**Subject:** R-6 Small Infill Design Review – 107 Monument Street

**Date of Review:** Thursday, July 23, 2015

On Thursday, July 23<sup>rd</sup>, a design review according to the *City of Portland Design Manual* Standards was performed for the proposed new construction of a single-family dwelling at 107 Monument Street. The review was performed by Caitlin Cameron, Urban Designer, Planning Division of the Department of Planning & Urban Development. The project was reviewed against the *R-6 Small Infill Development Design Principles & Standards* (Appendix 7 of the Design Manual).

ELEVATIONS
 DATE: 7/20/2015 DRAWN: KWB
 PROJECT NO.: 2015-03 SCALE: 1/4" = 1'-0"

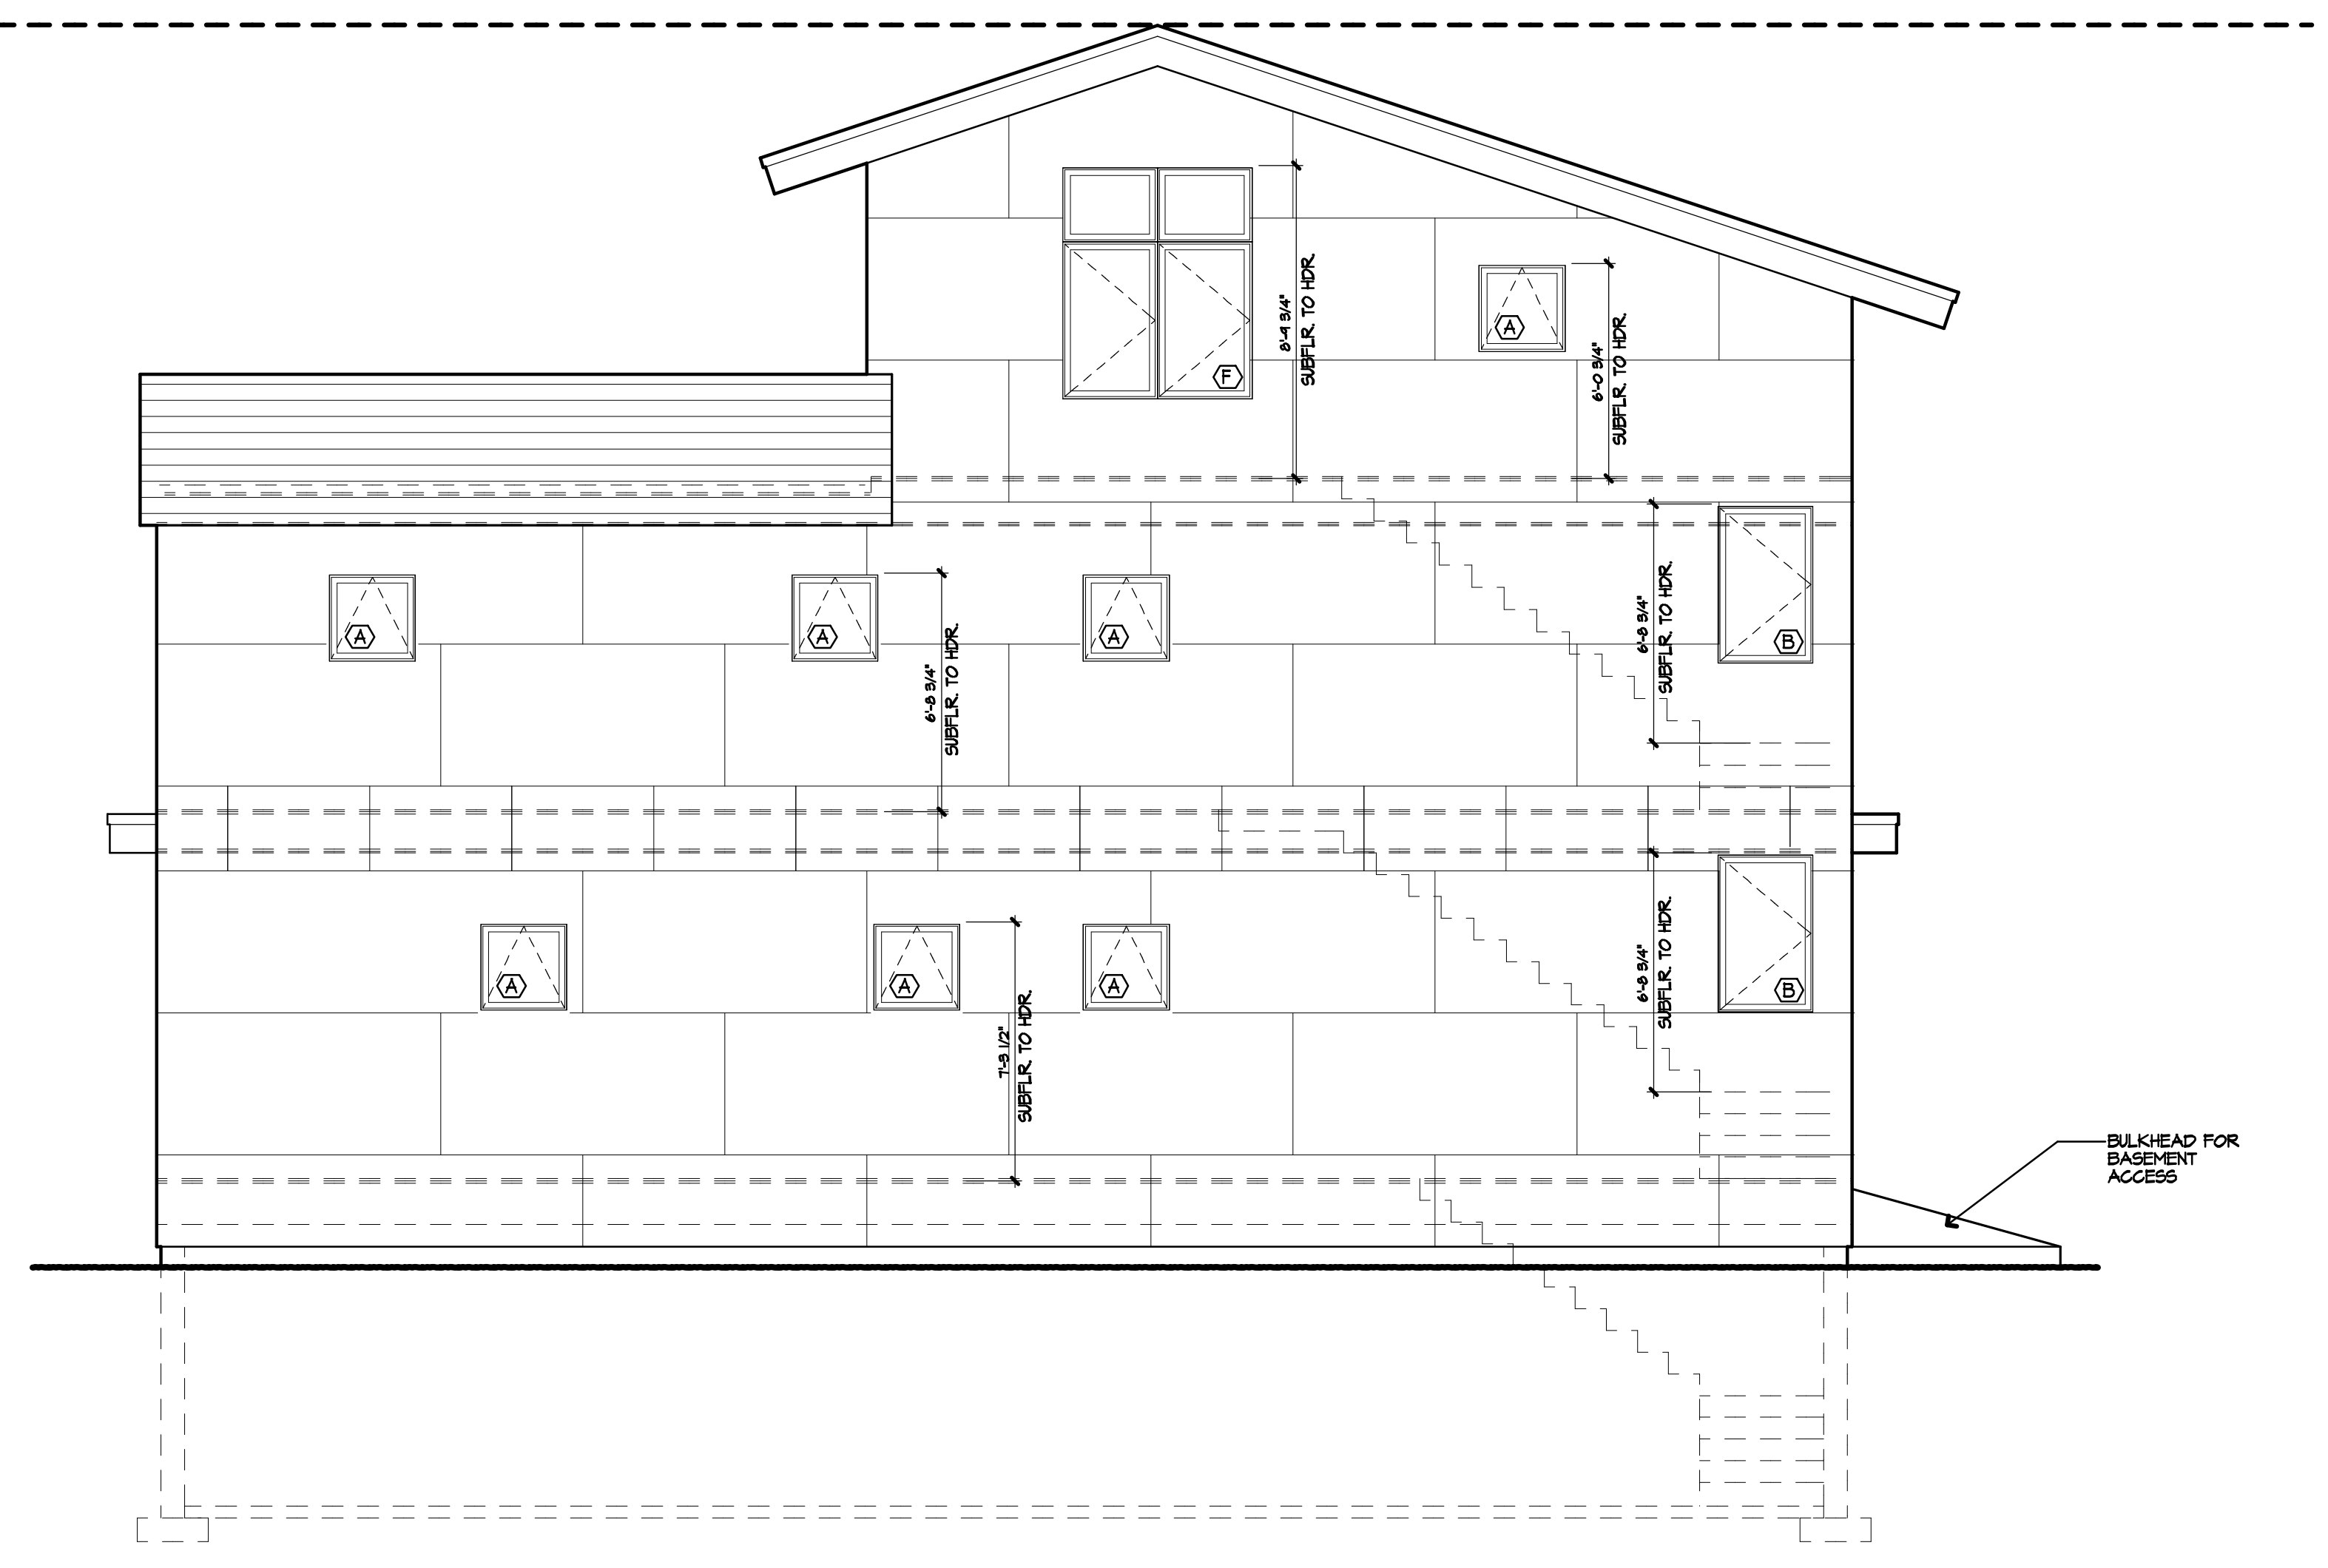
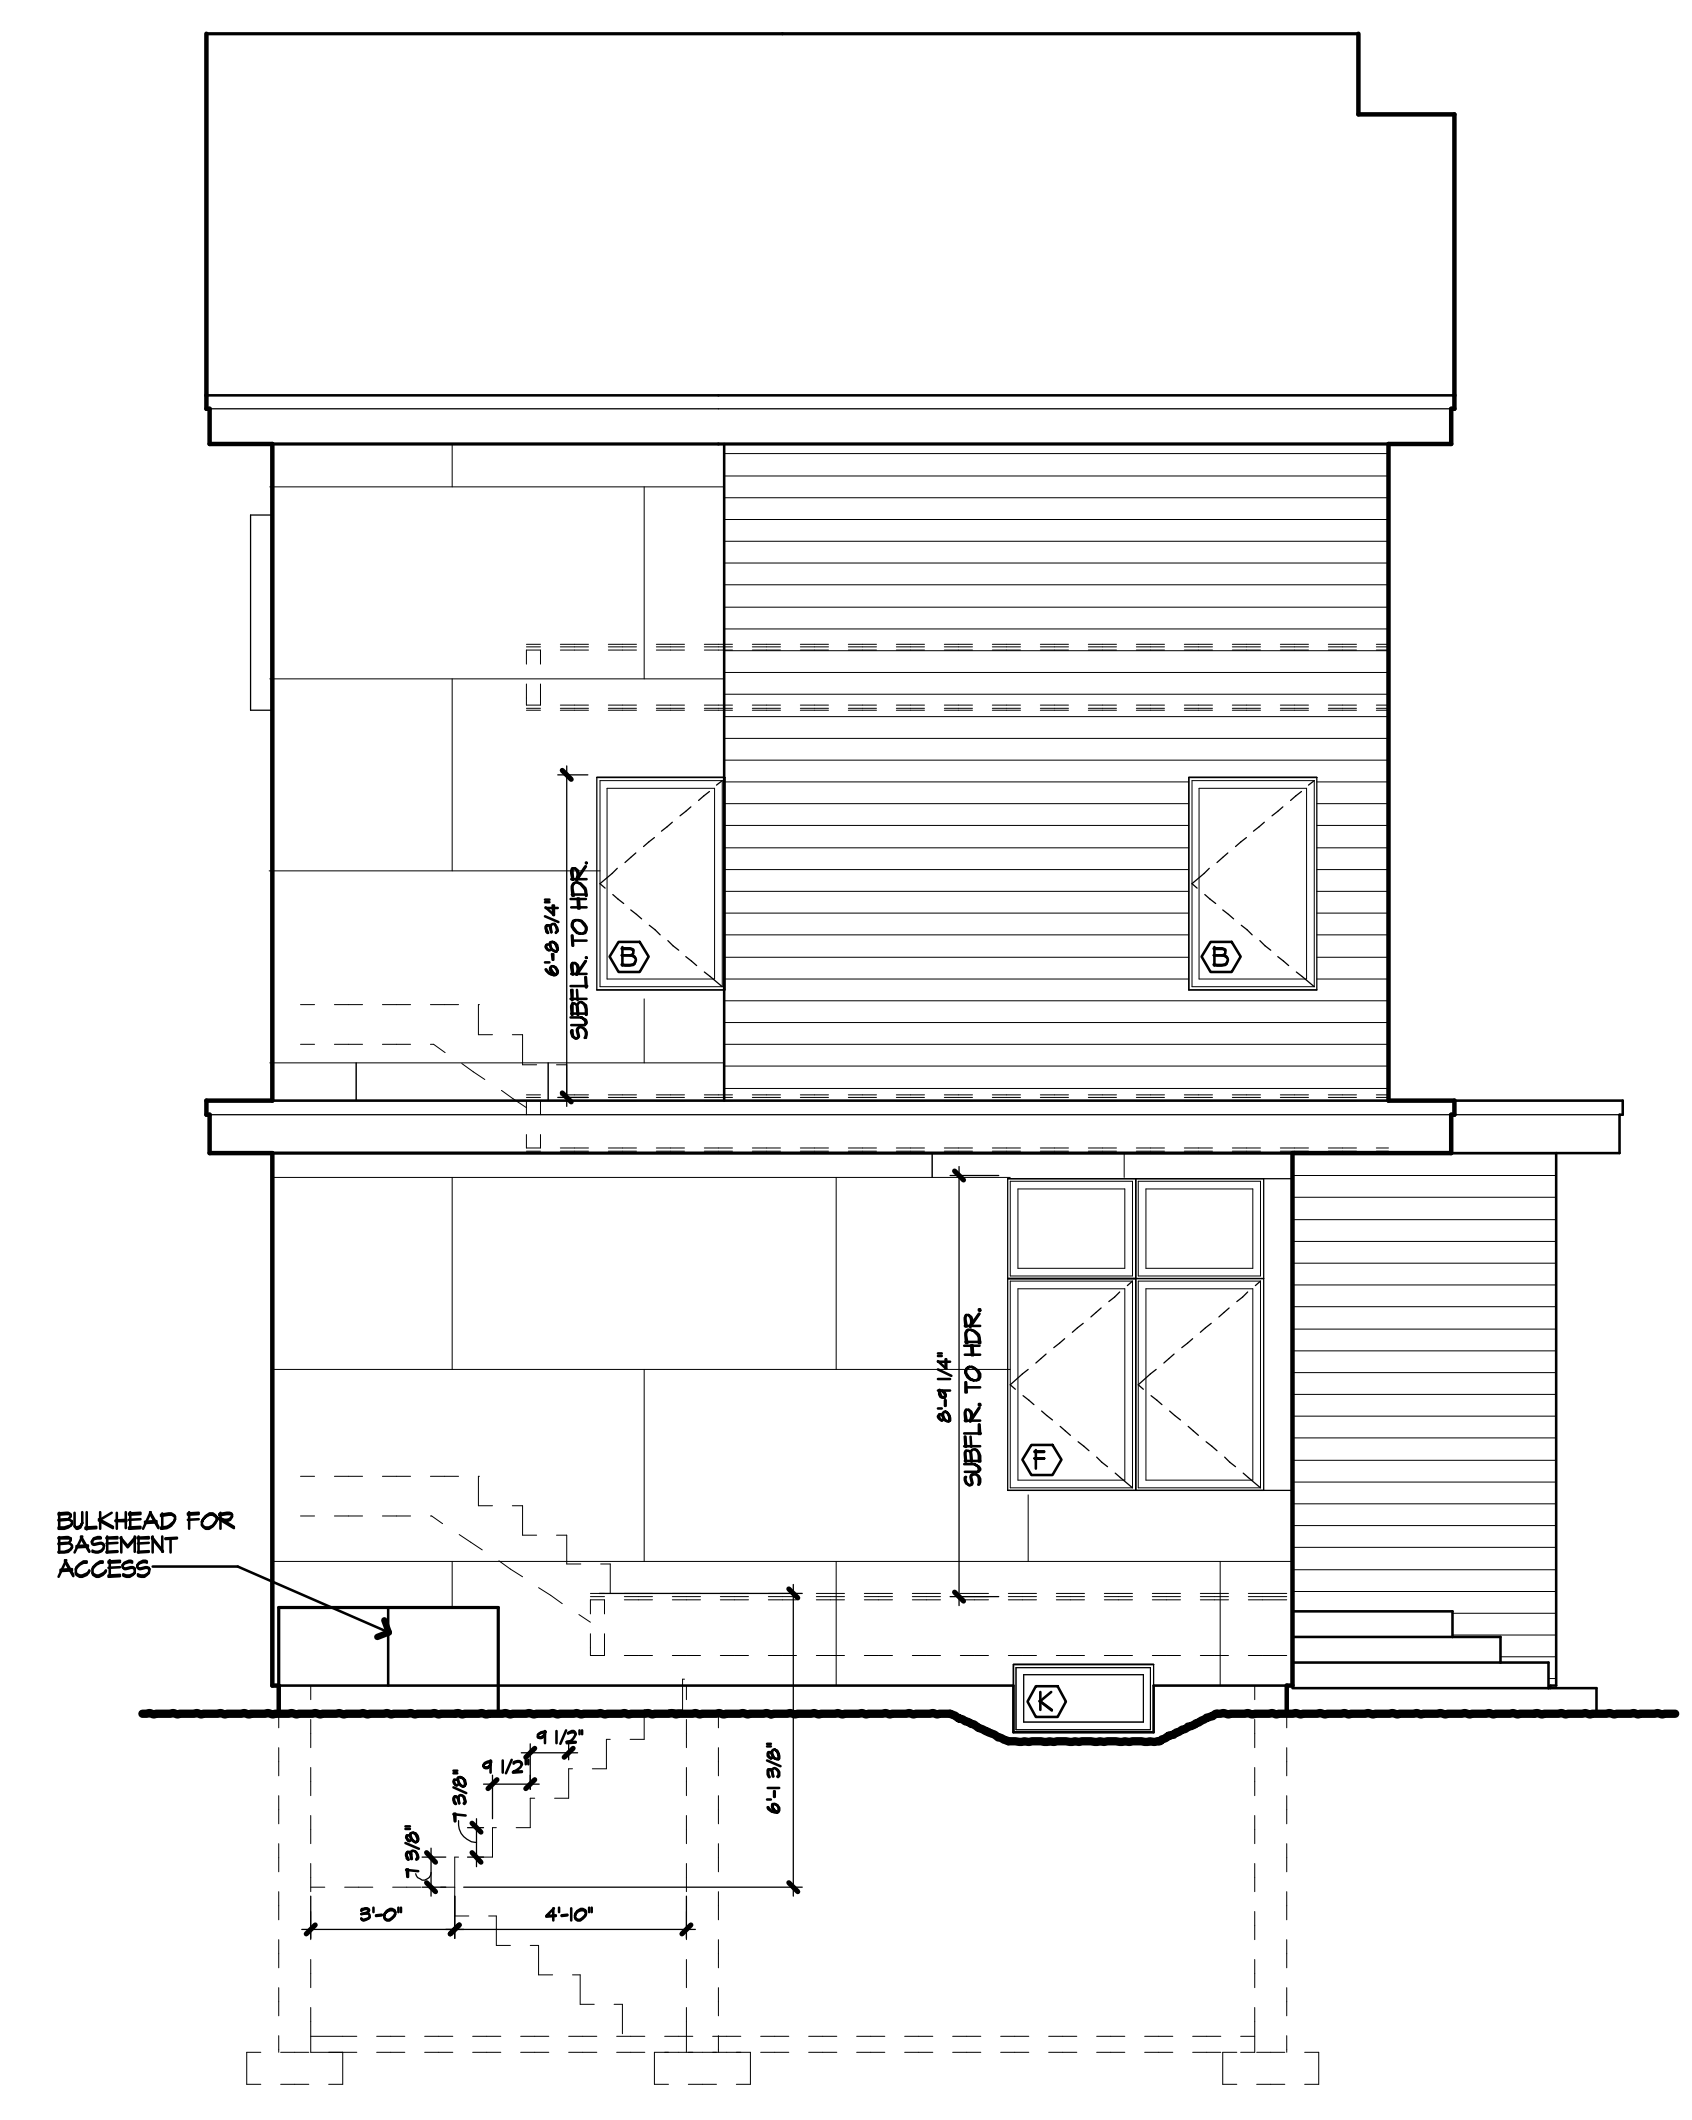
- *G-2 Material and Façade Design:* The materials are appropriately placed according to their nature. The exception is the use of clapboard on the parapet/balcony edge at the front of the house. A lighter material, such as a rail should be considered. The use of shingles, a solid wall, and a rectilinear line creates a heavy form at the roof lines of the two-story mass.

- *G-3 Chimneys:* Chimney not indicated on elevation drawings. Presumed to be metal.
- *G-4 Window Types:* More than two window types are used.
- *G-5 Patios and Plazas:* Not applicable
